**Newcastle Jockey Club – New Stables Complex (SSD-12982045)  
Request for Information**

Attachment A – Key issues

## **ATTACHMENT A – KEY ISSUES**

LANDSCAPE CONCEPT PLAN 02
Scale 1:250 @ A1

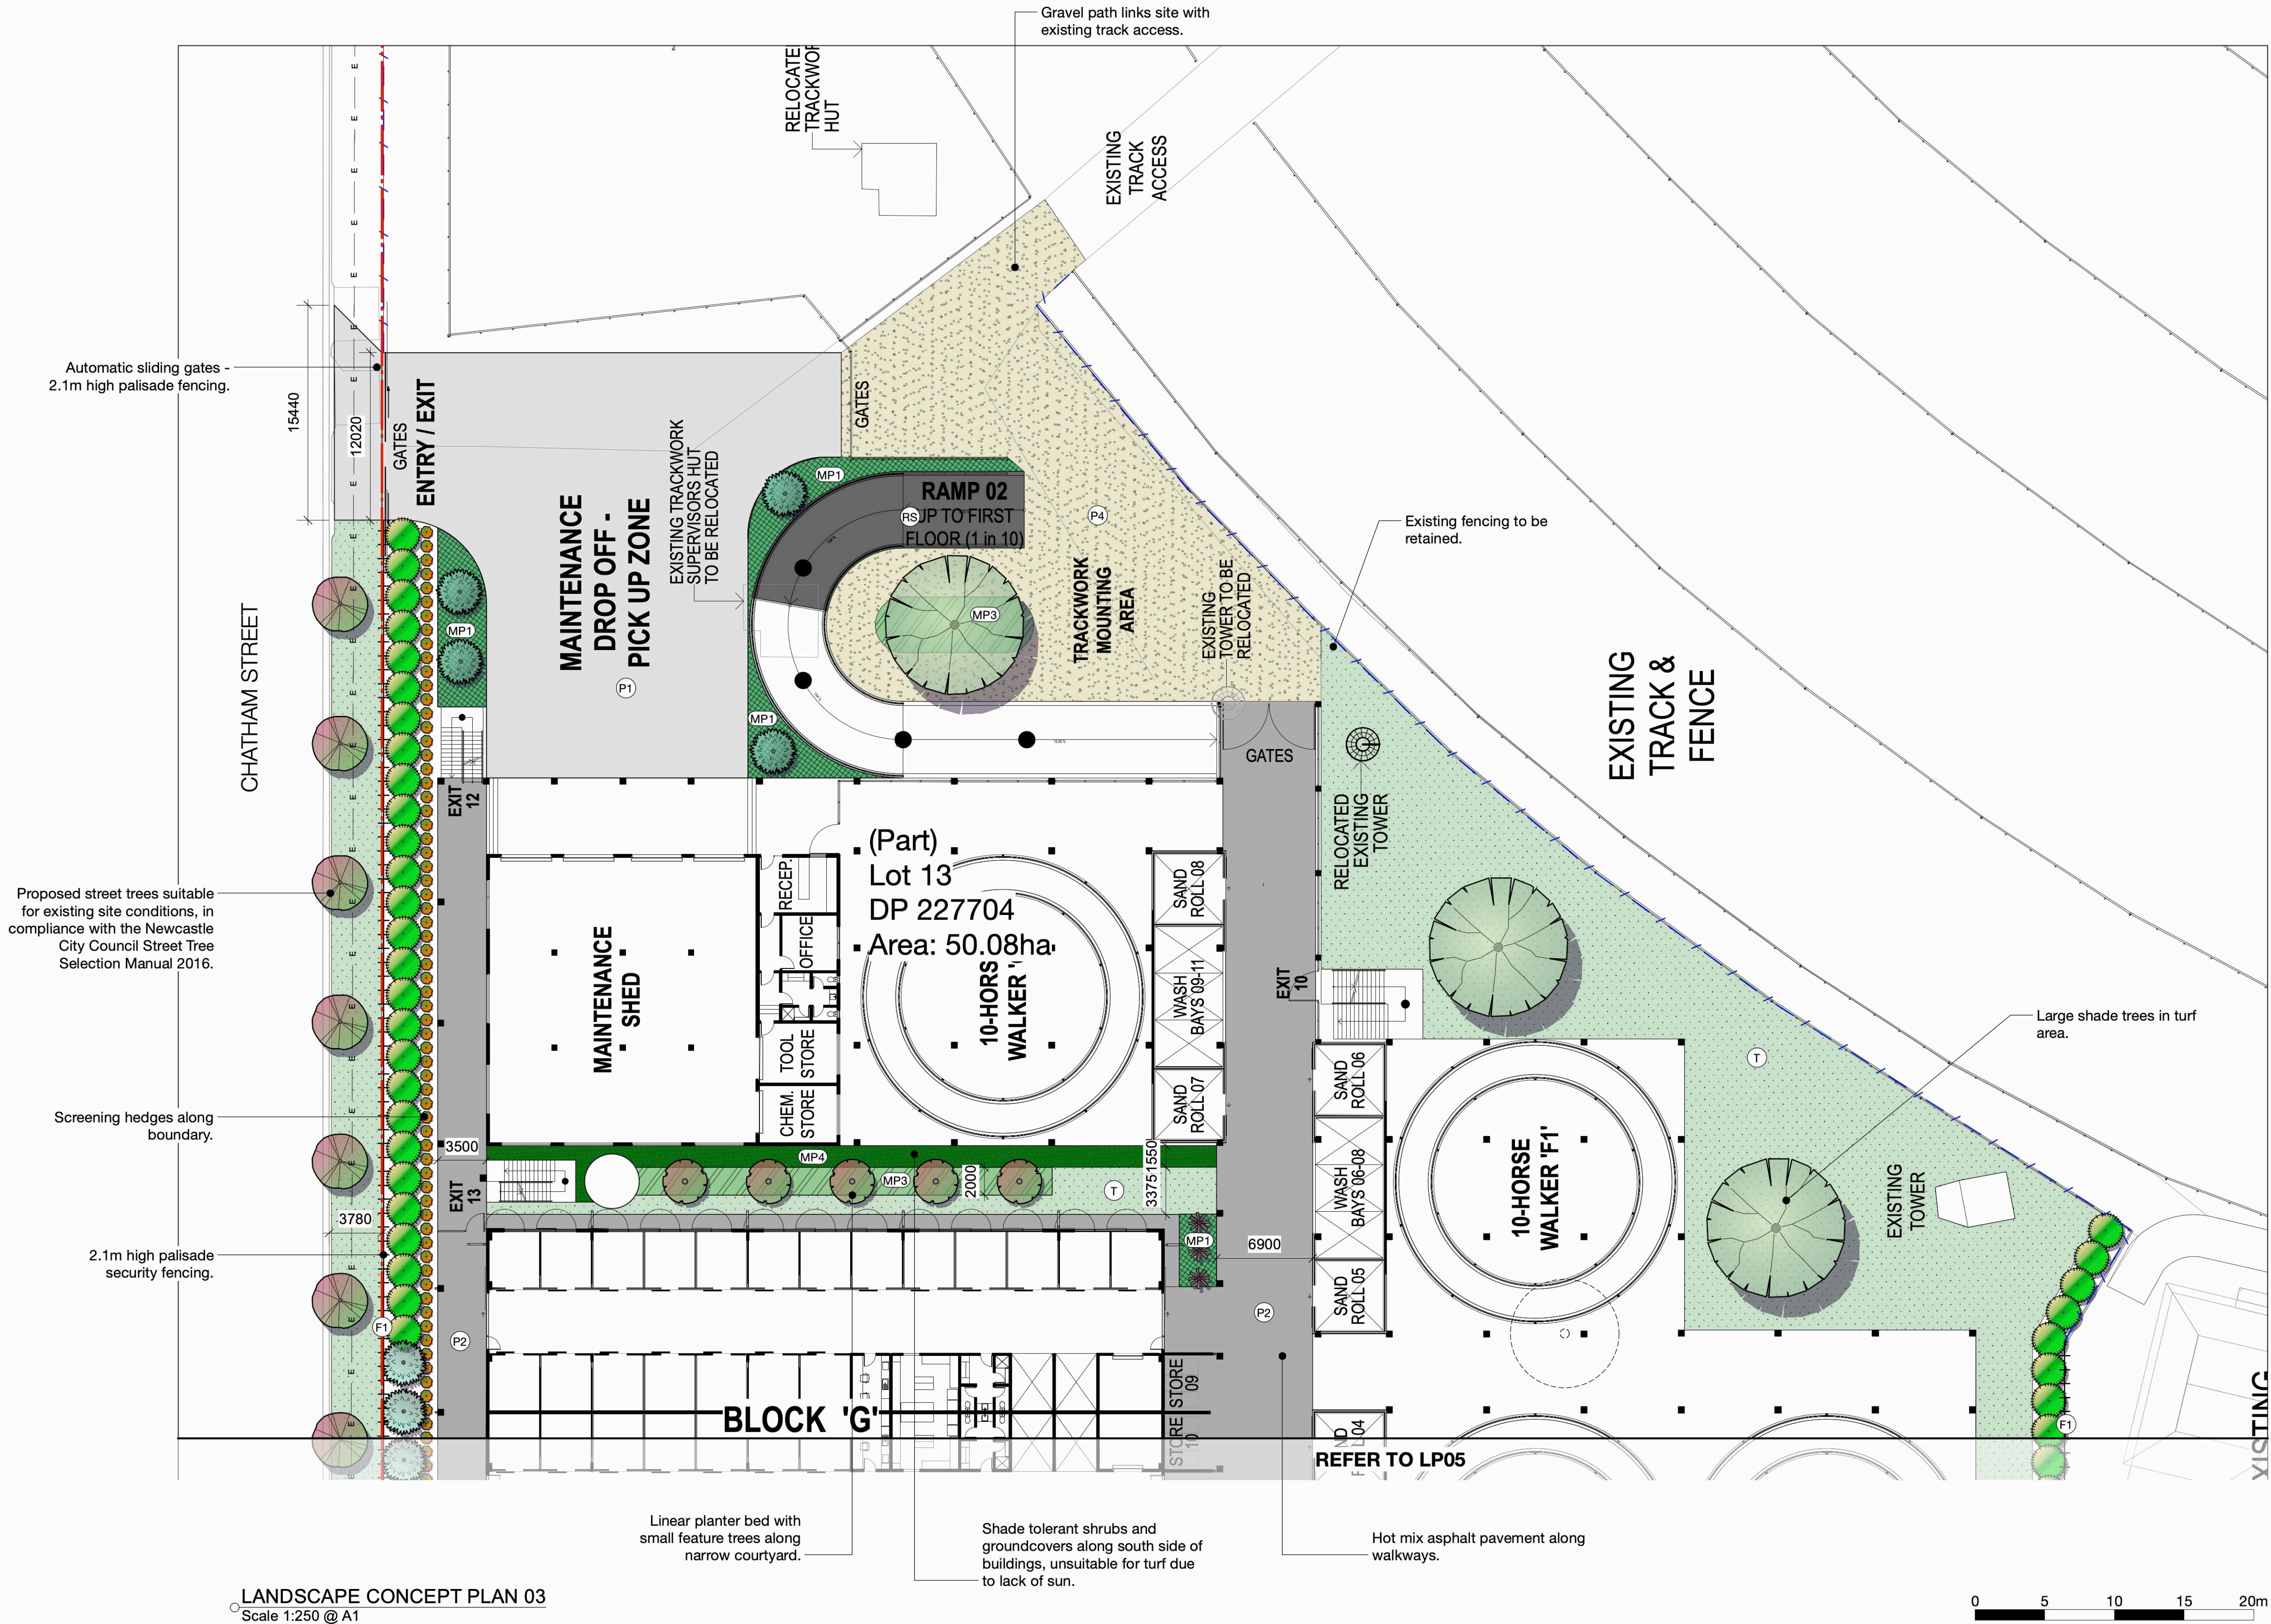
The proposal relies largely on landscaping elements to create visual screening to soften visual, bulk and scale impacts. Landscaping proposed to provide visual screening must be located within the subject site. Whilst vegetation (existing or proposed) within the public domain will contribute to an improved streetscape setting, it cannot be relied upon for visual screening.

It is noted that pot sizes and mature heights of plantings are provided on the drawings, information on proposed 'height at planting stage' is required for proposed plantings along Chatham and Darling Street to assist with the assessment of the application. This vegetation must be at an advanced stage at the time of planting.
